Application No: FG/150/21/T
Site Address: 1 Sea Lane Close Ferring BN12 5DT
Description of works: Fell 1 No. Monterey Cypress tree (T1) and fell 1 No. Austrian Pine tree (T2).

Thank you for your internet representation made on 7th September 2021 which has been recorded as an objection with the comments as follows:

T1 - Monterey Cypress (Right) & T2 - Austrian Pine (Left); observed from Sea Lane

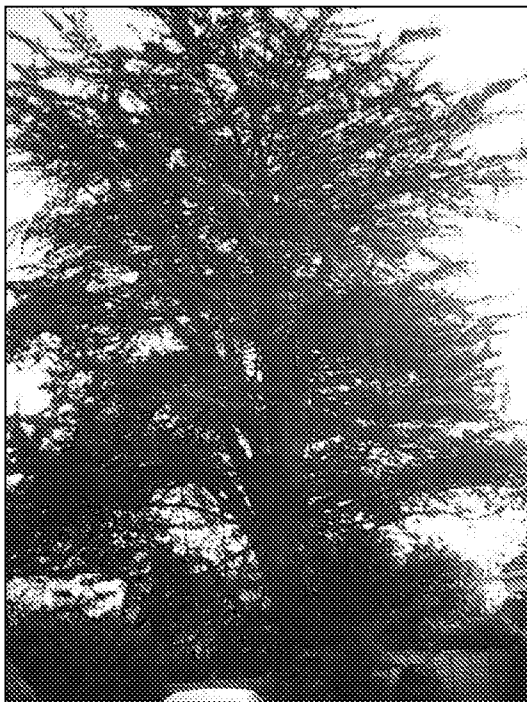
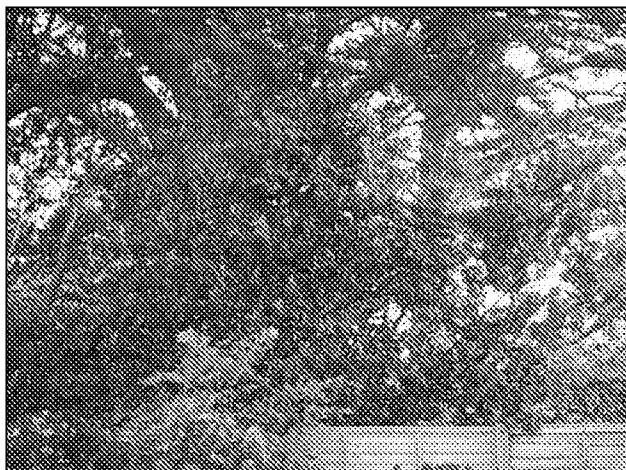
Ferring Parish Council strongly objects to this application based on the fact that the removal of trees would have a significant impact on the street scene and that there appears to be no clear evidence of damage to bungalow.
